August 31, 2012

TO: Nelle Donaldson  
Barbara Barhydt  
FROM: David Margolis-Pineo  
Dept. of Public Services  
RE: Review Comments: 433 Fore Street – Canal Plaza Hotel

EXHIBIT-04

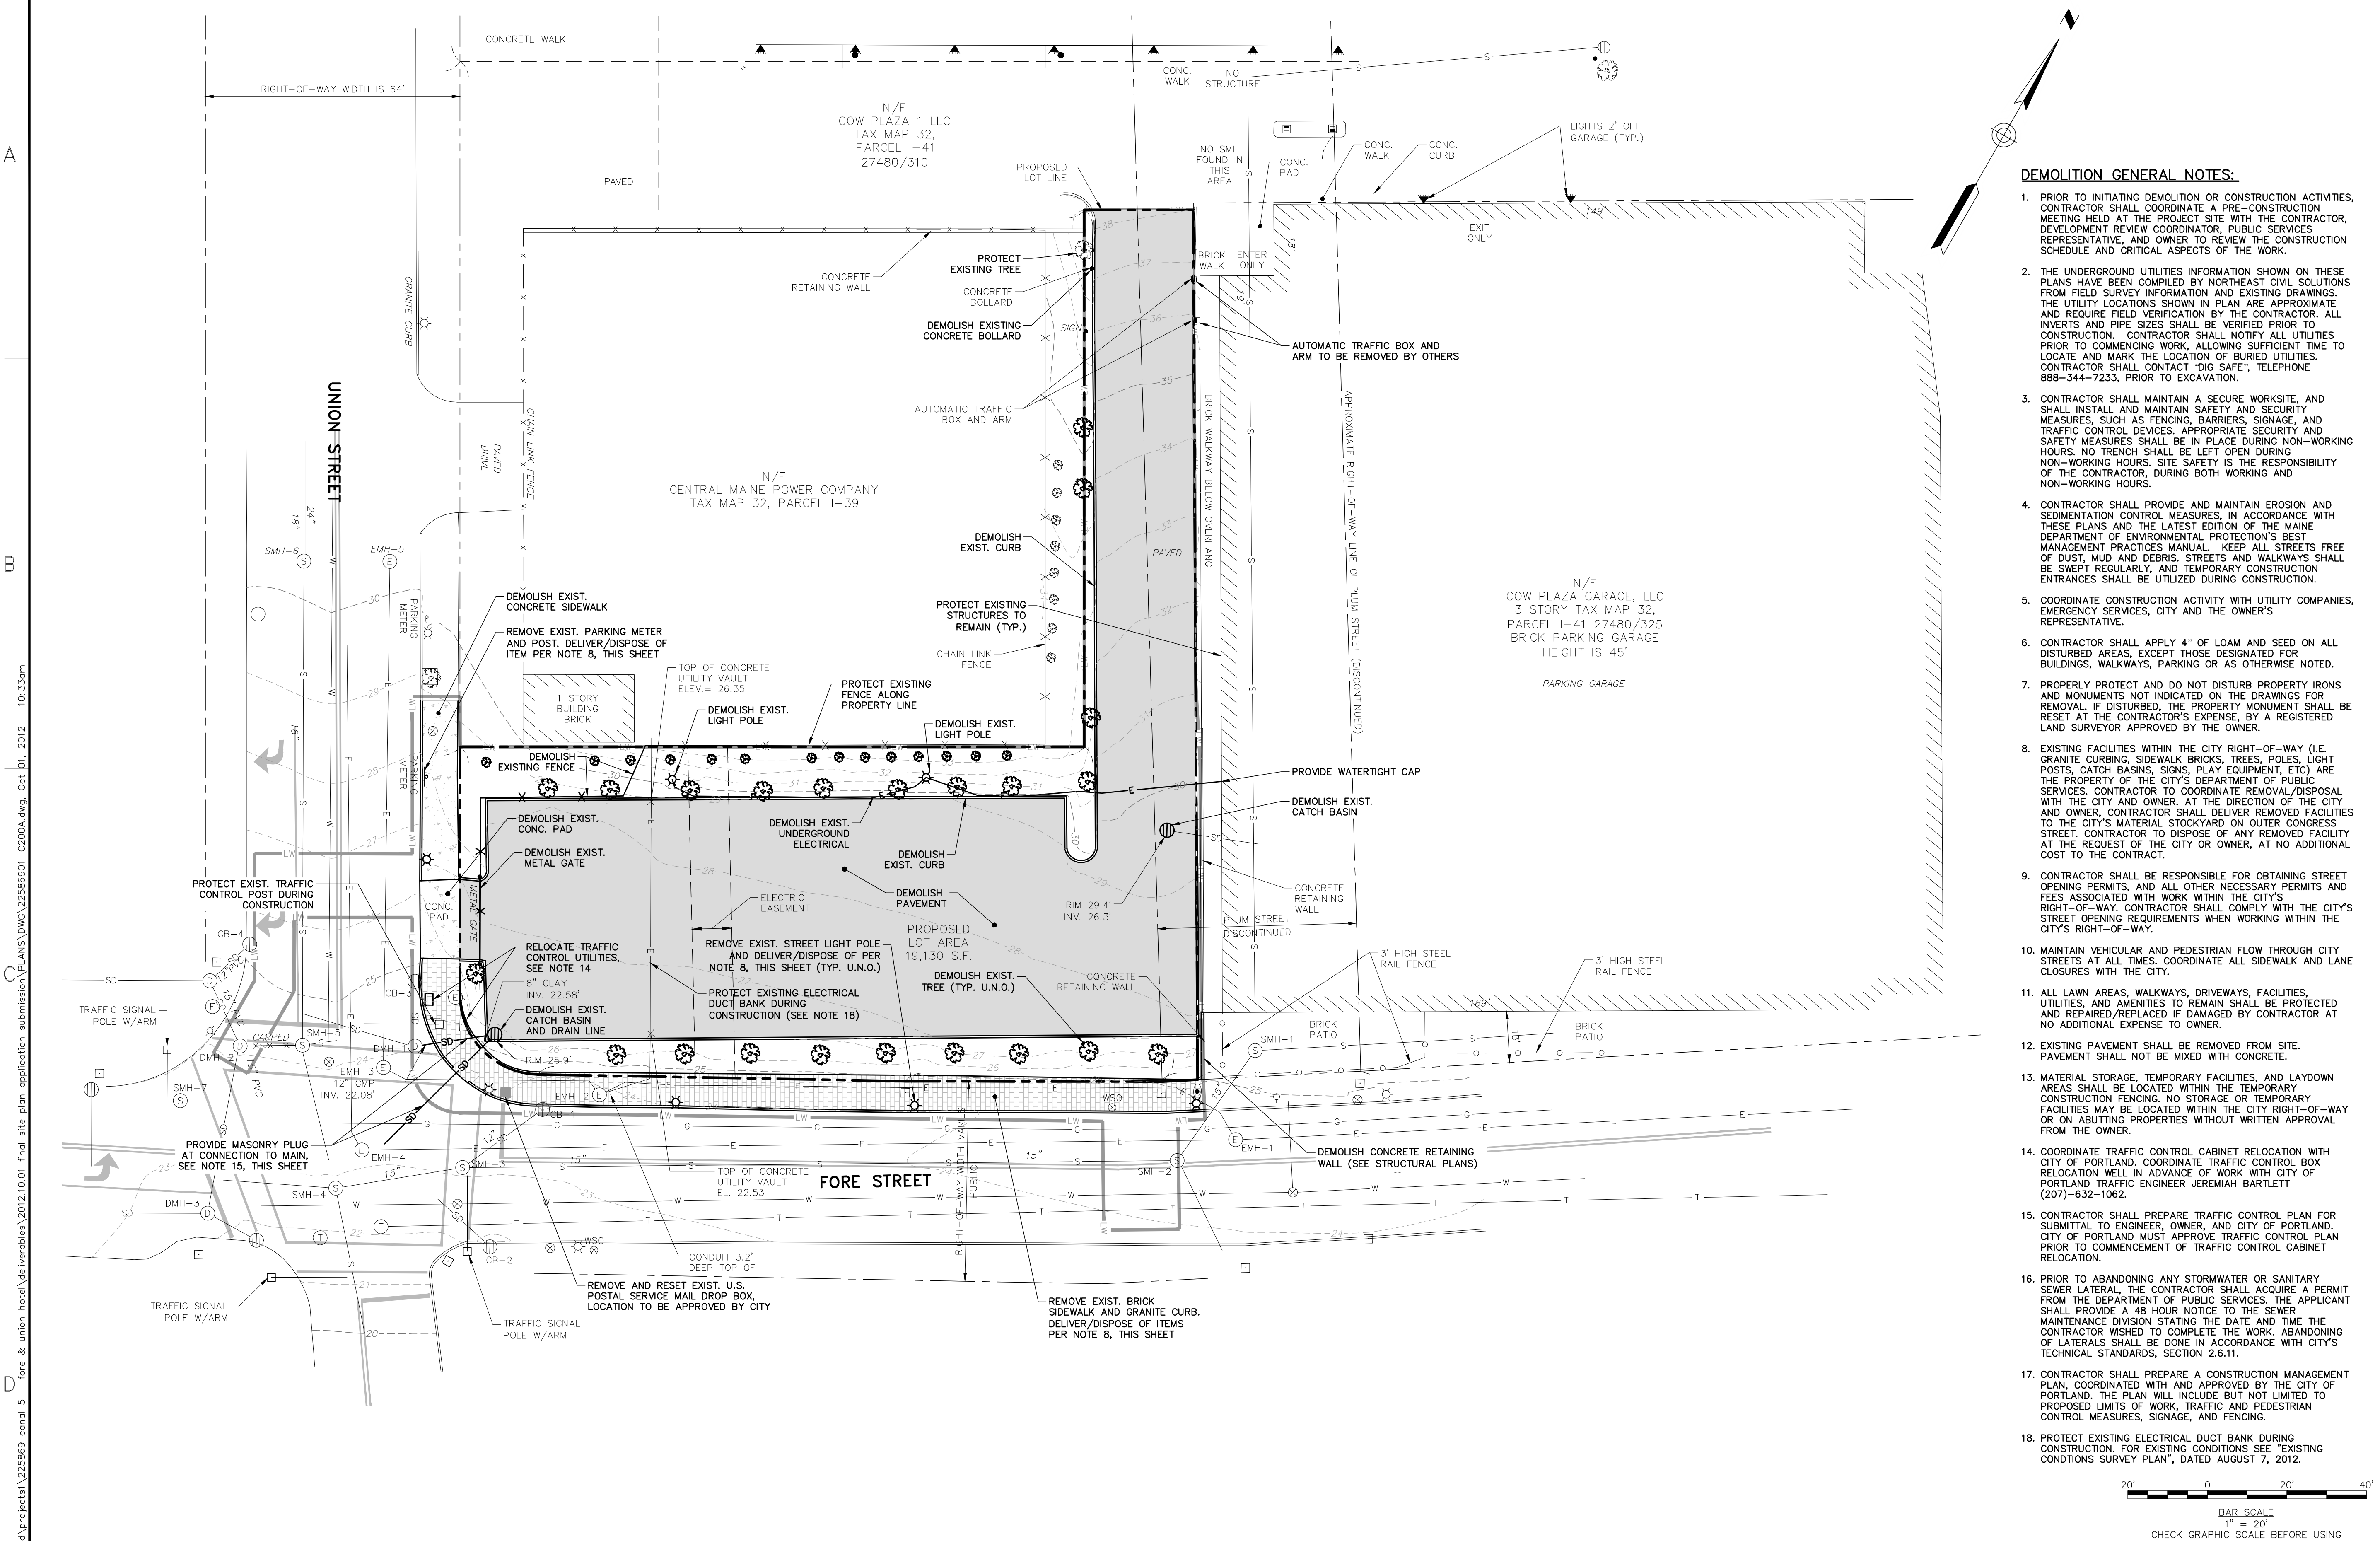
2. The City is requesting verification that Central Maine Power is aware and okay with the construction of a building on their easement.
1. The applicant is proposing to remove and plug several drain lines. The applicant's attention is directed to section 2.6.11. of the City's Technical Manual for the requirements to plug abandoned sewer laterals. Please add note to the plans directing the demolition contractor to this City requirement.

UTILITY PLAN

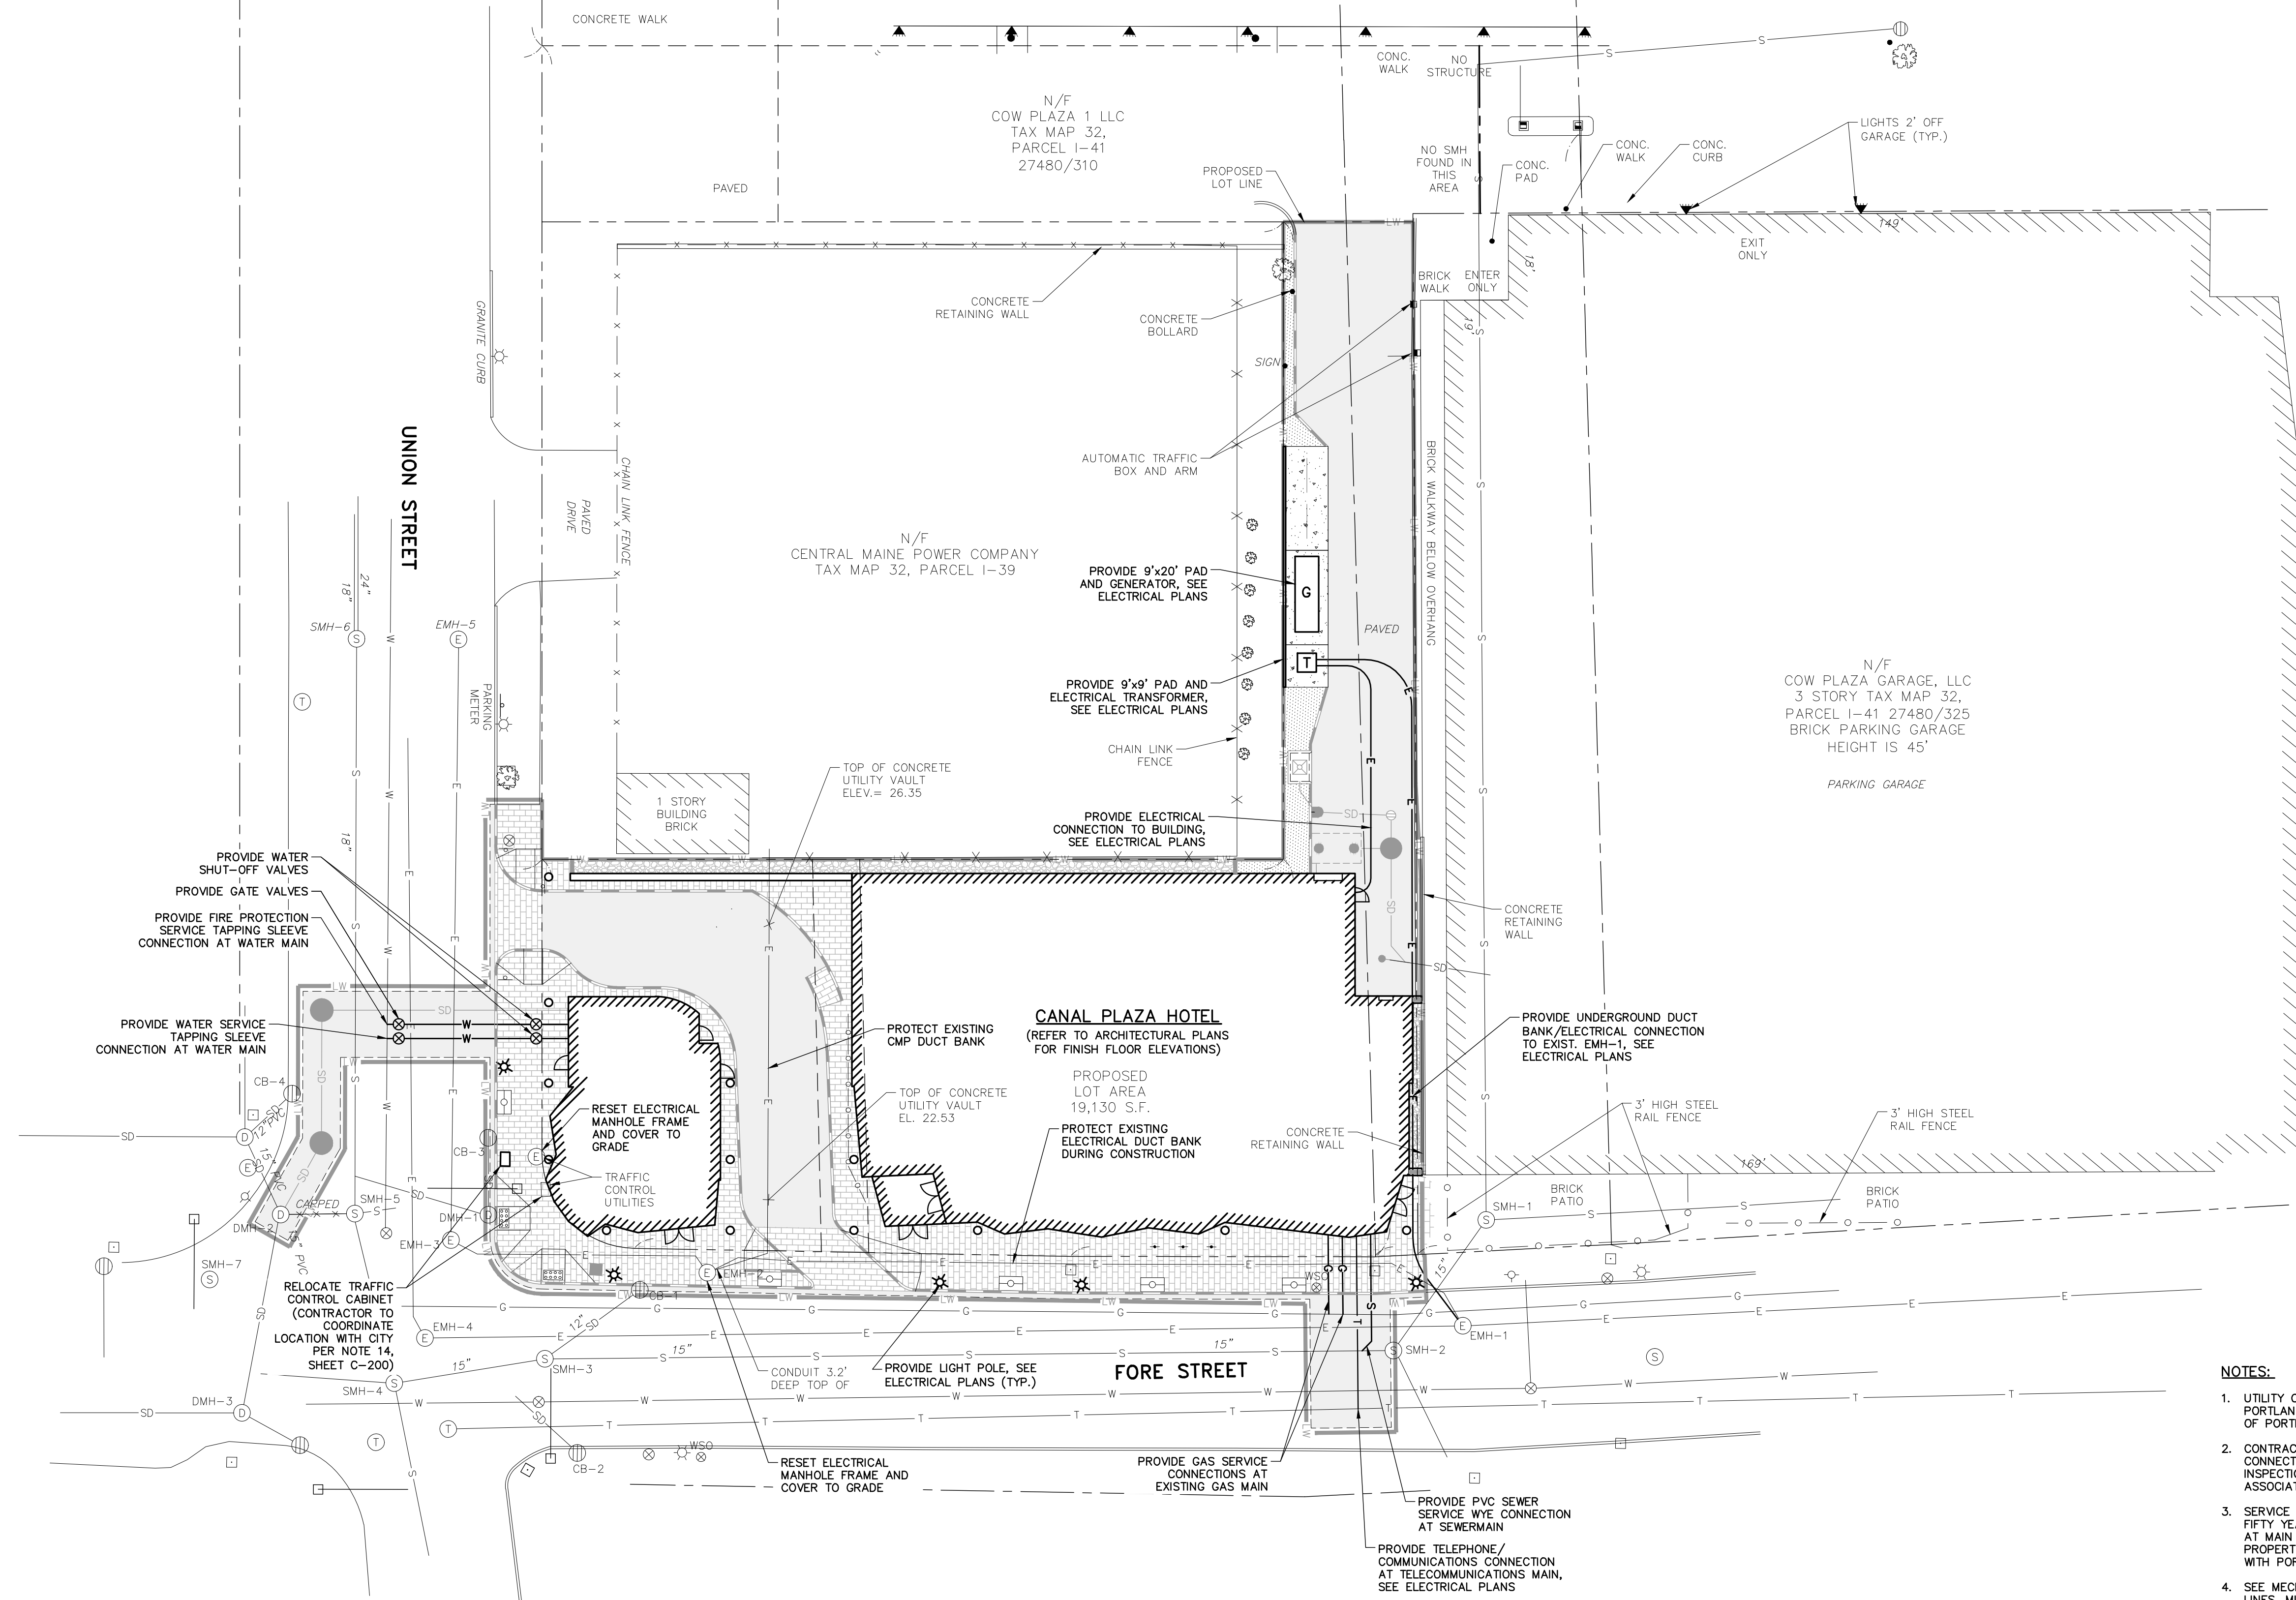
3. The sewer system is combined in this area. It would be advantageous to separate the stormwater down Union St to Commercial where there is a stormwater sewer. The City would be interested in receiving a contribution to do this work.
